**ADC Planning Consultation
Response from the Historic Buildings Adviser**

Application Number	BR/97/15/L
Address	67-69 Upper Bognor Road, Bognor Regis, PO21 1HR
Description	Application for listed building consent for repairs to existing slate roof covering, removal of dormer roof to lean to roof, replacement 11 No. timber windows & 2 No. doors, repair/replace timber porches, repair to existing rendered elevations & replacement of cast iron rain water goods.
Case Officer	Simon Davis
Site Visit	Previous

Rev Date Notes	
PROJECT	67-69 Upper Bognor Road BOGNOR REGIS CAMPUS
DRAWING	ELEVATIONS EXISTING AND PROPOSED
SCALE	1:50 © A2
DRAWN BY	HS
DATE	March 2014
DWG.NO.	BRC_005_01 A
REV.

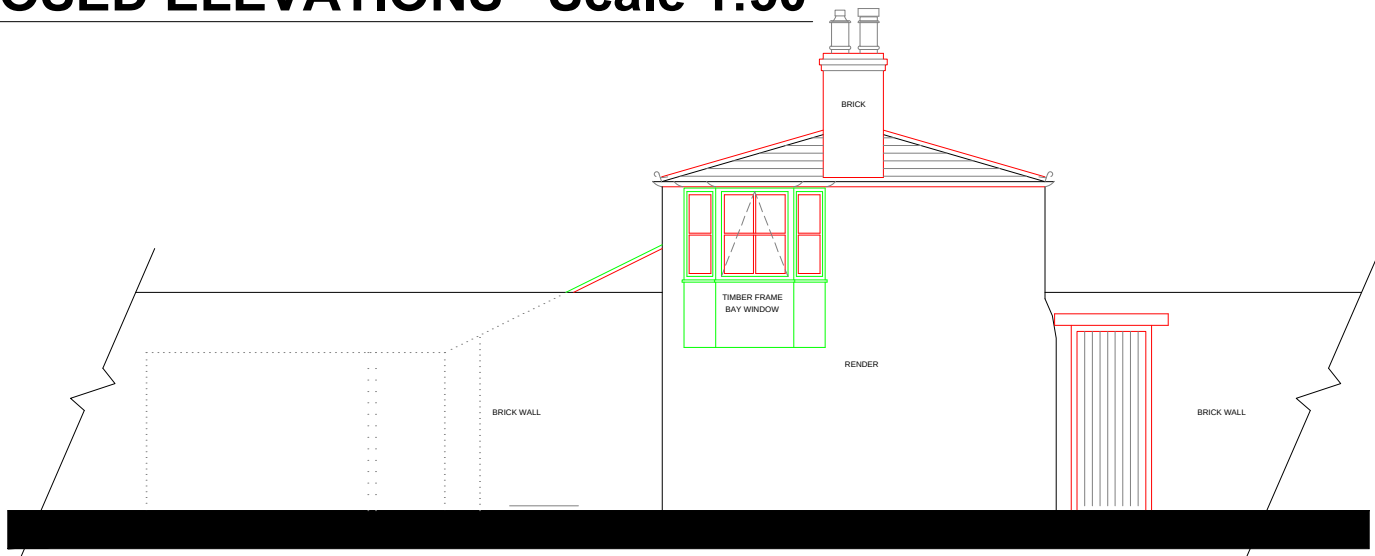
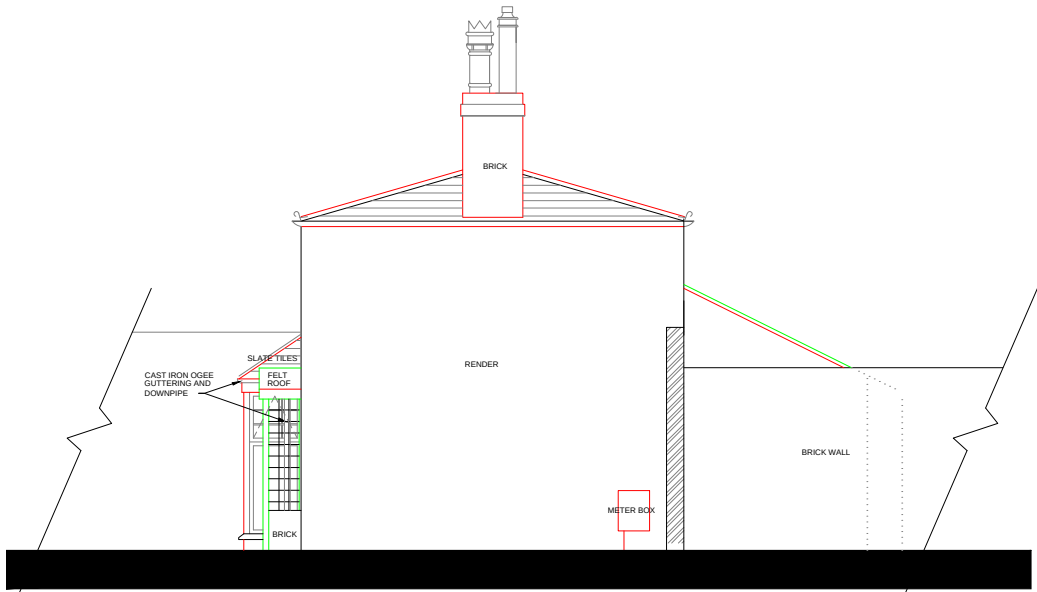
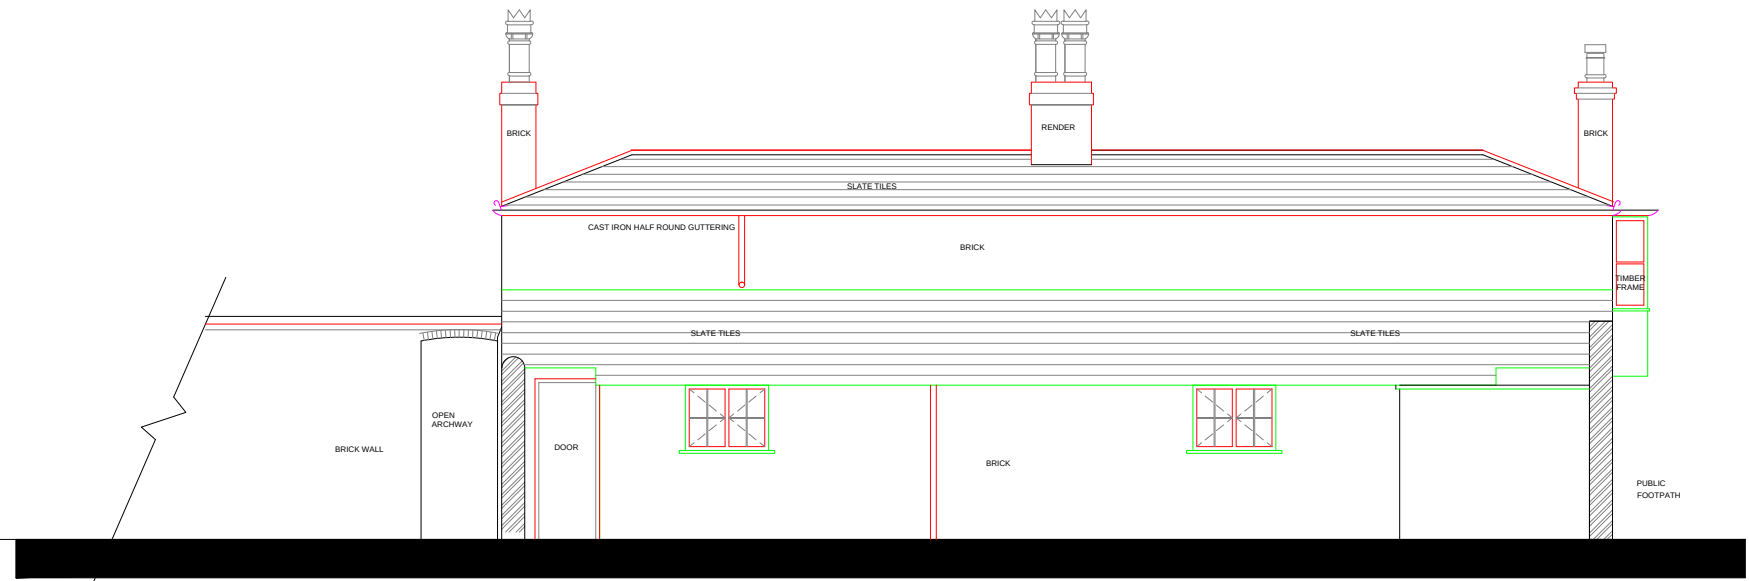
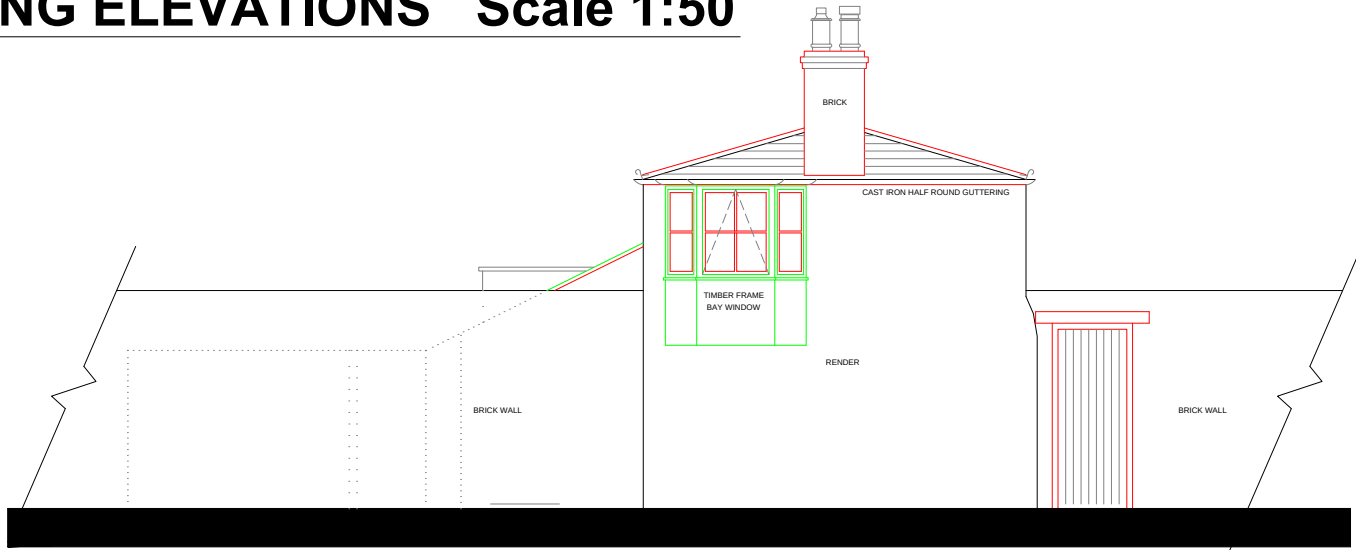
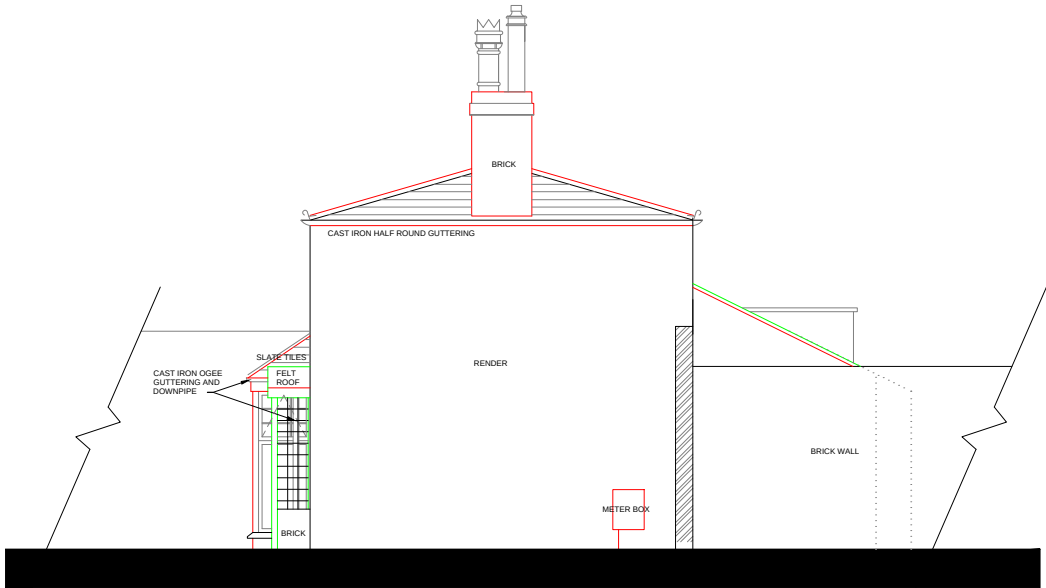
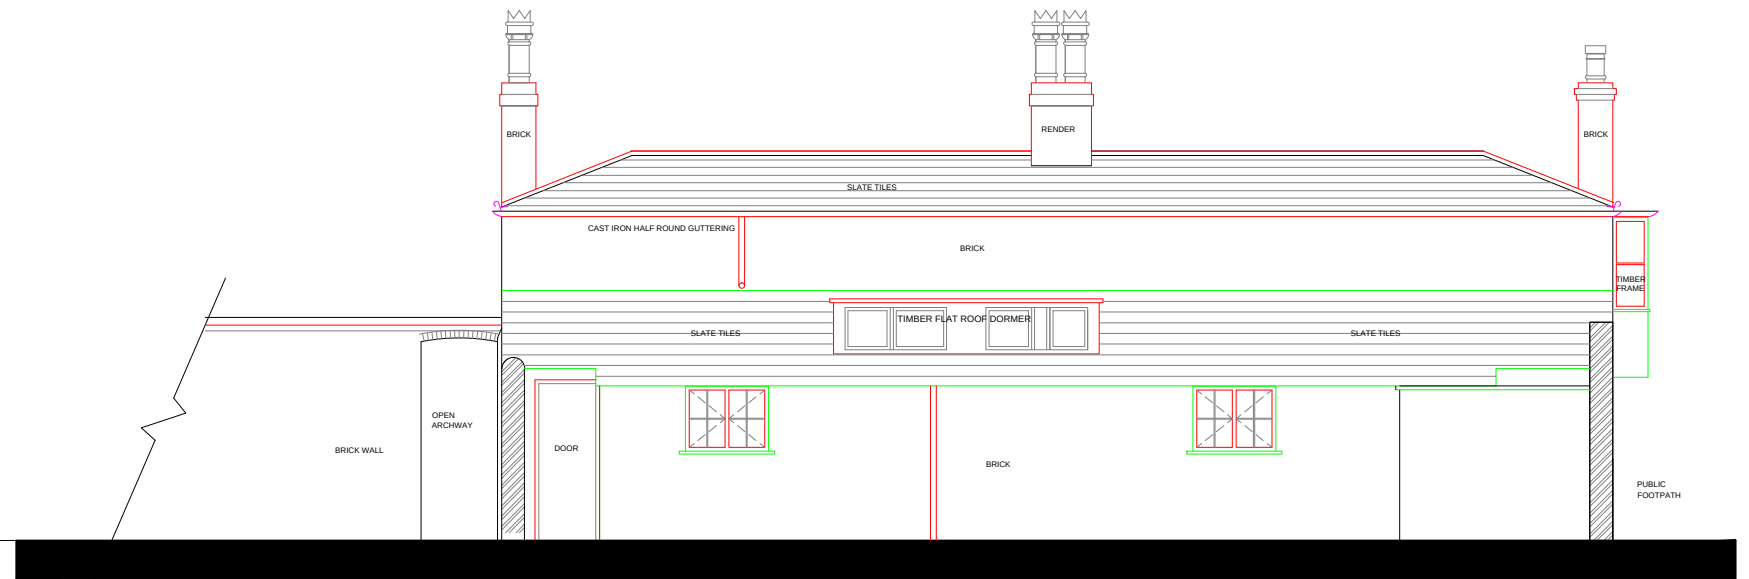
On the basis that the windows are single glazed and copy existing.

- All window and door details
- Sample of rainwater goods (or image and details)
- Detailed drawings for replacement porches
- Method statement for repairs of render
